### ISH2 Weds 7 Dec\_Part3

Yep. Great. Thank you. Okay, so what now? To section four of the agenda, which is cultural heritage.

This image provides landscape and visual context only

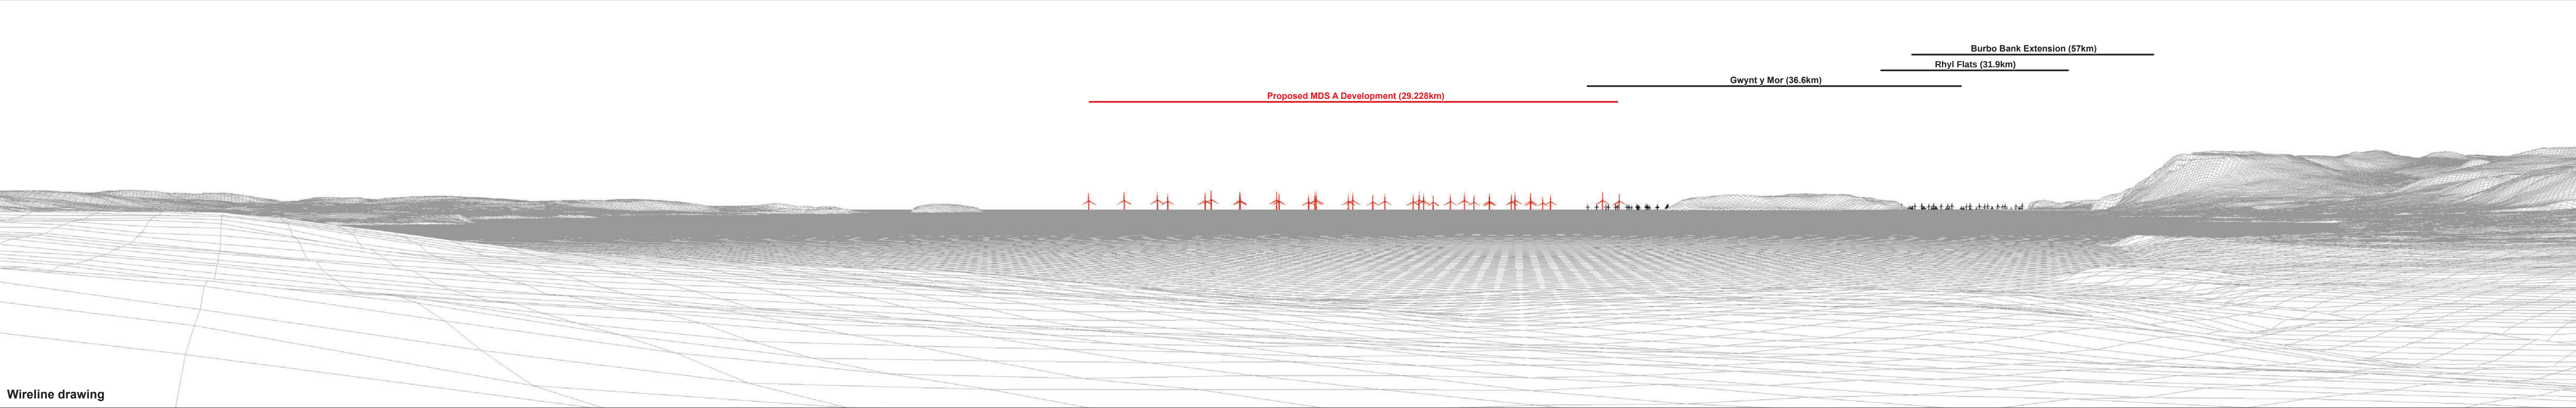
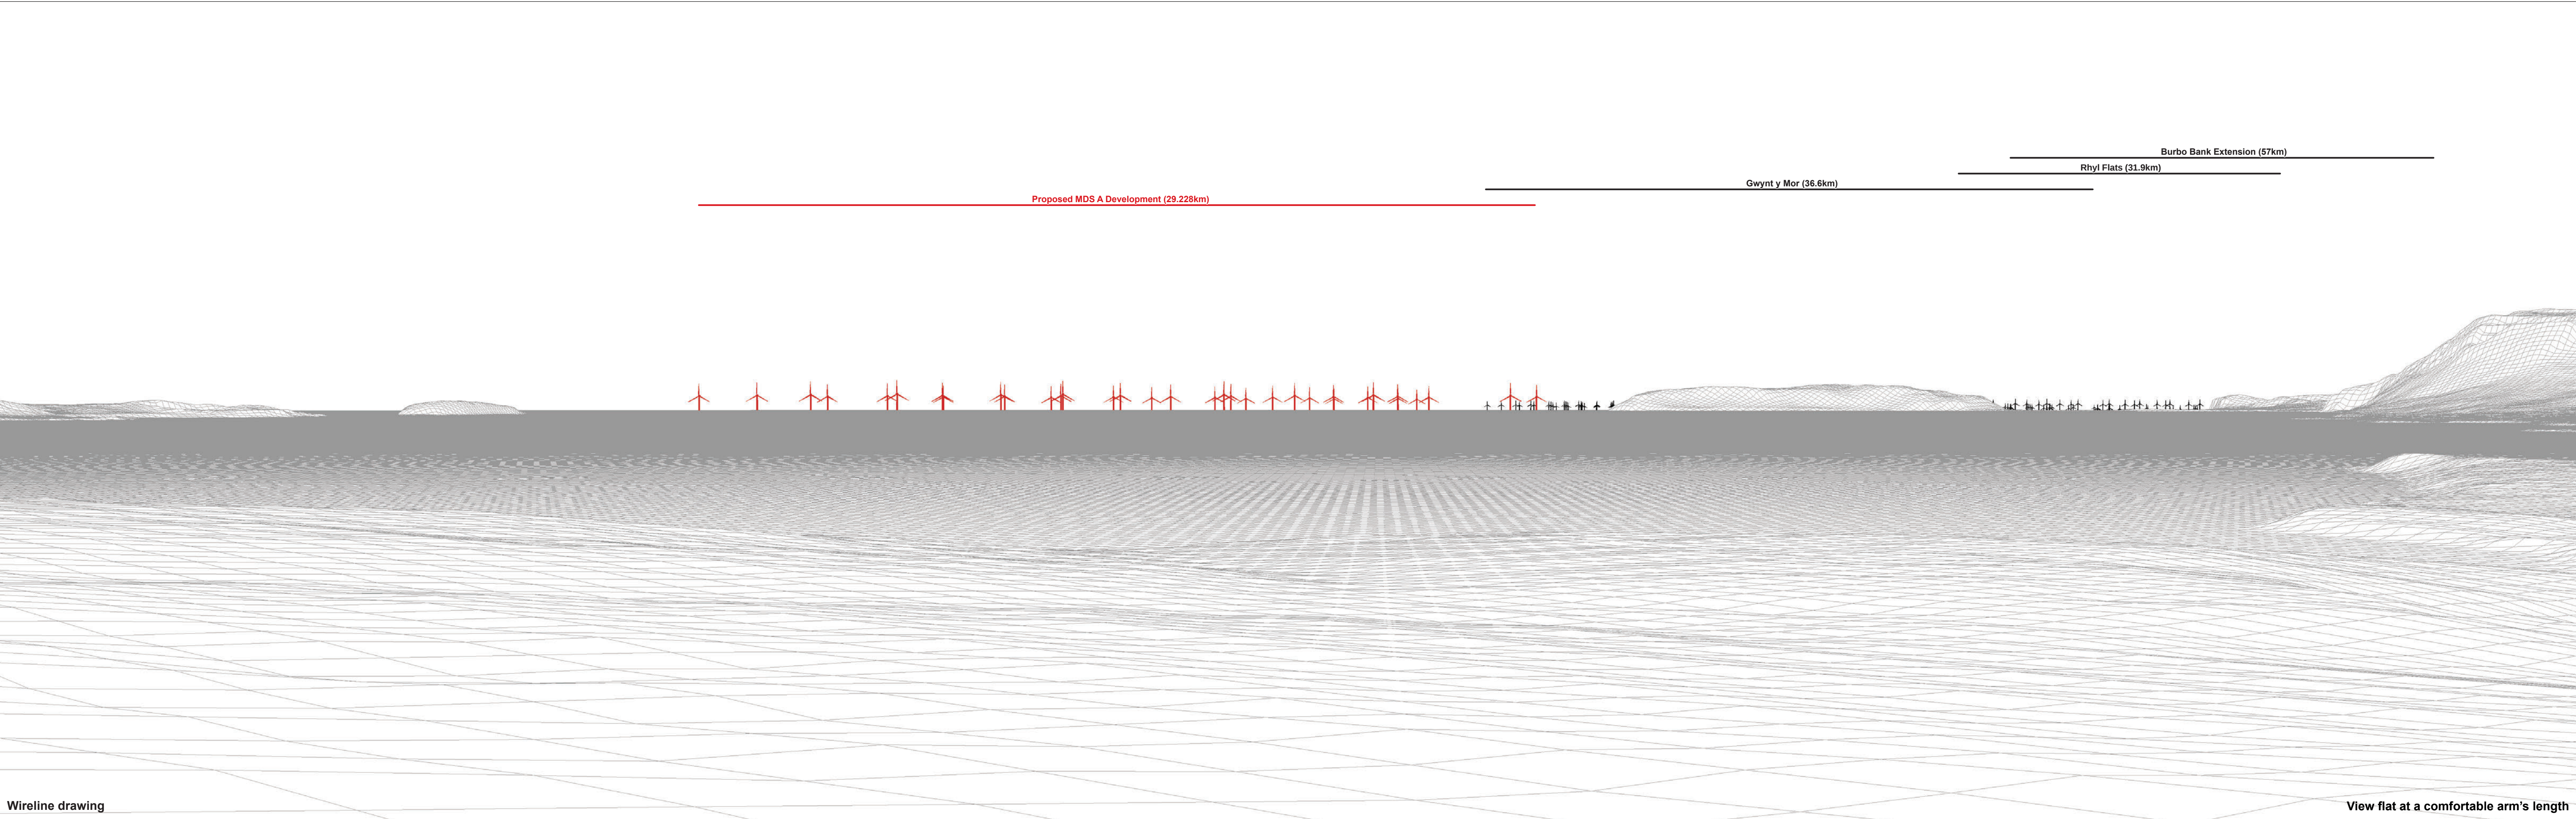
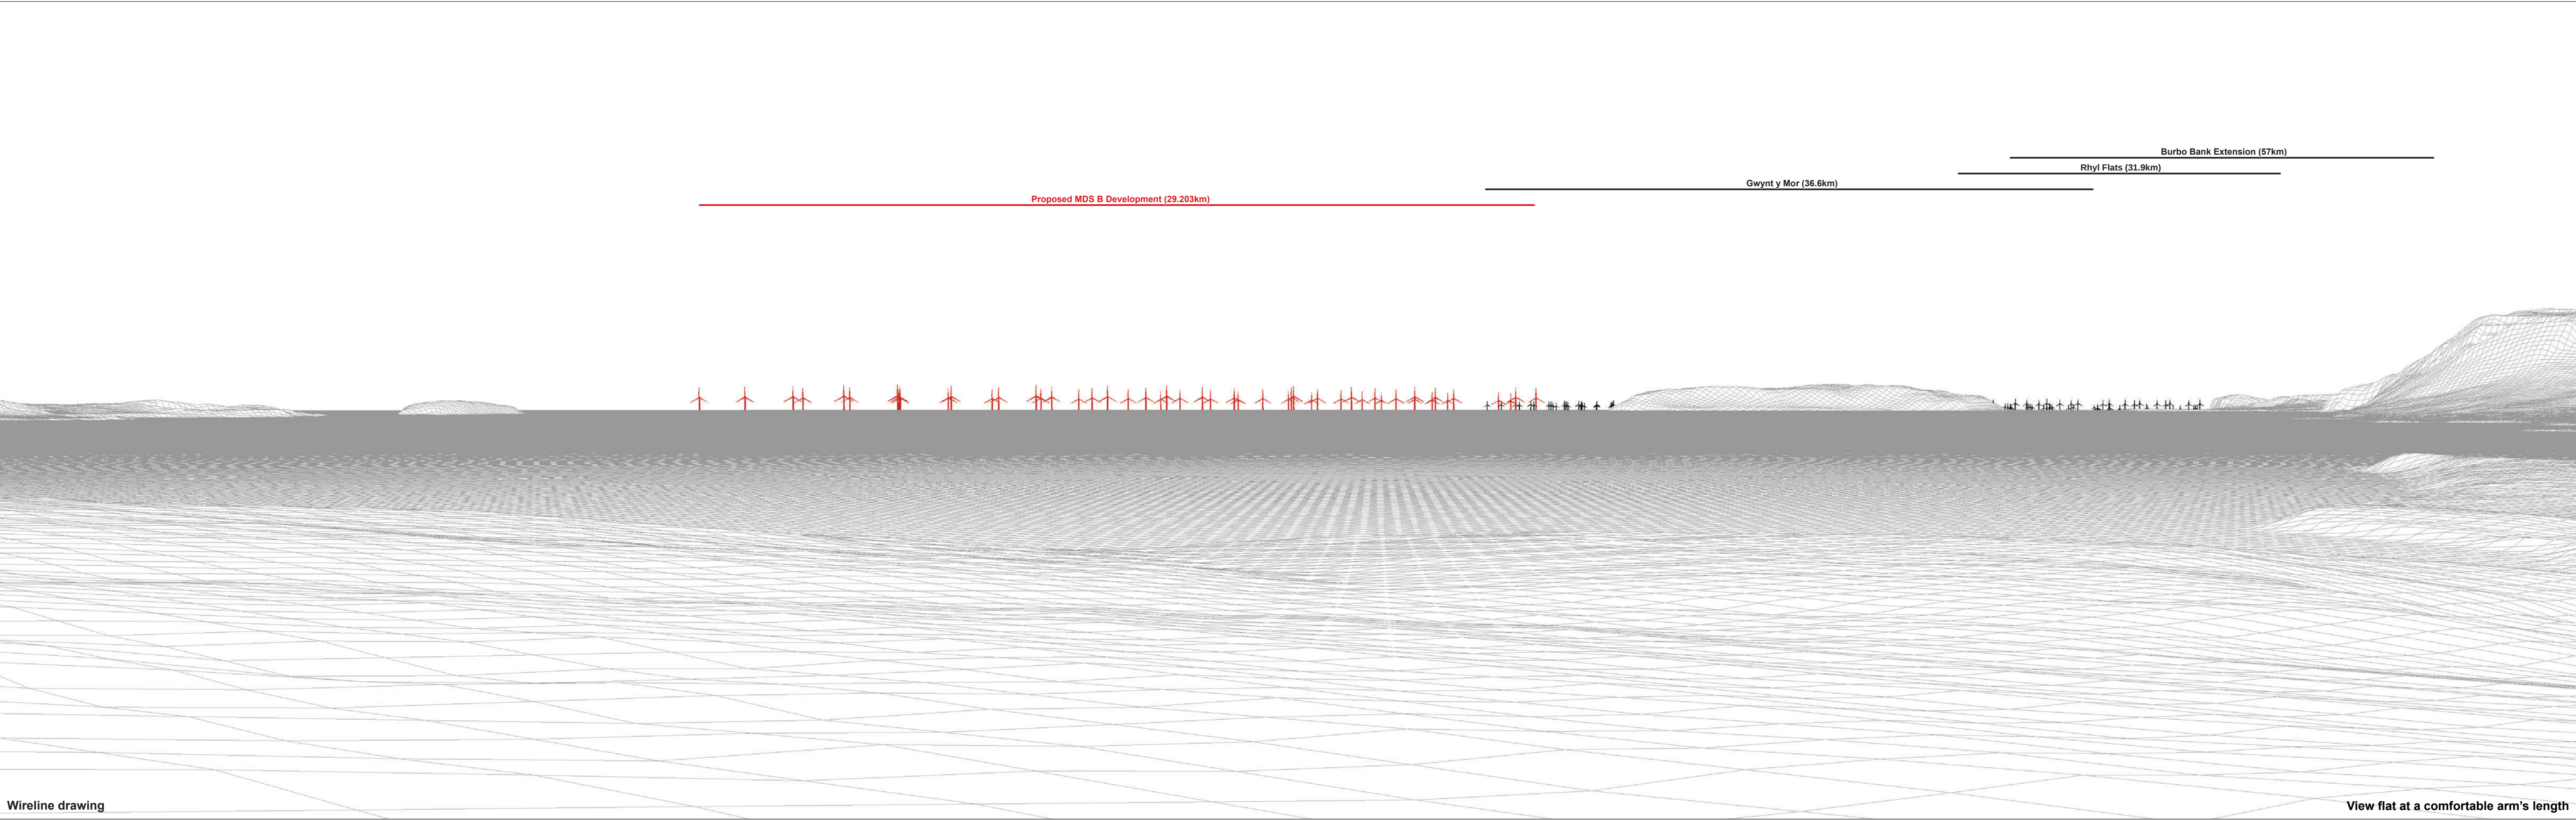
I was just I noted in the end that a listing for the rest of Park and Garden states that significant views include views for the main entrance of the house and the Barbican Terrace, which obviously we have a visualisation from on the east side, offer the best views towards Penmaenmawr and comedy, The view and the quotes. A view of the park, coast and hills is spectacular.

So my question is, would the construction of the project have an effect on those views? Introducing a new element into the largely countryside and seaside based views that are presently recognised in the listing?

you can't just focus on what is not affected. You need to acknowledge what is affected and give that due weight. Is the view from the terrace. Looking out towards the sea is important. It's an intentional view design view and the beauty and scenic quality of that view is important and it looks, it leads the eye to the horizon and as such towards the overseas estates, the plantations and the problematic slavery connection that was the source of the and state.

the new development that the turbines would fill that framed view. It would have me say it would foreshorten the view and detract from the and the experience. I guess that the intended aesthetics of that view. And so in that particular view, I would argue that the the impact is of some significance. It doesn't disrupt the relationship between the estates and seeing it, you know, moving.

And the thing is there's nothing immediately blocking in the in the in the foreground, but it is a conspicuous impact on that one setting and reduces the contribution of that view

Mark TONER on behalf of the applicant. It will certainly introduce something new in view. But it's the question I need to consider is to a degree, the view and what's in the view contributes to your ability to understand the Council's significance in terms of its other interests in the round and what part that plays in terms of the role of the park surrounding it as an appropriate setting for the castle and whether that's an armed.

In my view, whilst there is an addition in the view it does not so materially change the contribution made by the setting in the round to how you appreciate the castle when you circulate within its setting.

That the significance doesn't rely solely on that view. And in my view, you can still experience the intended relationship with the C, and I accept there are some design views throughout that landscape in different directions.

I don't believe that having the turbines in my view, prevents your association or understanding of the intentionality of the landscape in the design planting either in the case of that individual view or in the round.
